Fiona Gibson - RE: FW: 86-96 & 100 Mount street North Sydney_ Section 75 Modification for Commercial and Retail Development (MP08_0241 Mod2)

- Clarification is required in relation to the exact Gross Floor Area (GFA) for the proposal. Does the proposed 470 m² increase in GFA shown on page 37 of the Environmental Assessment (EA) Report incorporate the increase in retail space on the lower ground (89 m²), increase in plant room area (up to two storeys) and the ground floor mezzanine level as part of the proposed overall GFA shown on page 7 of the EA Report?

Area Schedule

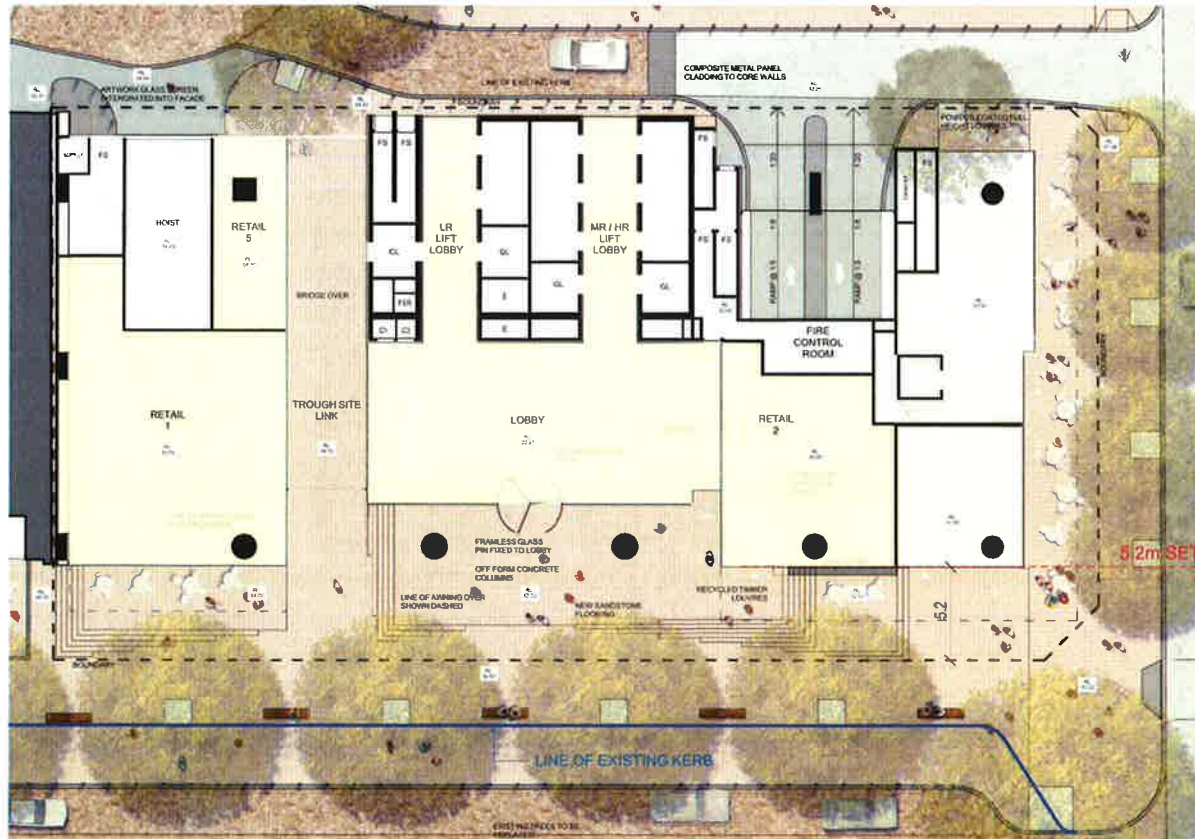
- In considering the above paragraph, the overall increase of 470 m² in GFA should be used for the contributions calculations shown on pages 37/38. Instead the calculations on pages 37/38 of the EA report shows an area of 351.149 m.² (presumed commercial GFA) used for the contributions calculations and clarification is required as to why the overall GFA of 470m² is not used in the calculations instead?

- 1) The proposal includes an additional 472sqm of GFA. Refer to Area Schedule DA139 Issue B attached (submitted with the EA) confirms the increase GFA calculation provided in accordance with Council's LEP definition includes the retail space on the lower ground, increased area on the plant level/Level 34 and the ground floor mezzanine level as part of the proposed overall GFA. Reductions in GFA are proposed on other levels of the building.
- 2) We accept that Condition B6 Railway Infrastructure will be modified to account for the increase in non-residential GFA. We note Council's submission includes a recommended amendment to condition B6.
- 3) Refer to response to point 1.
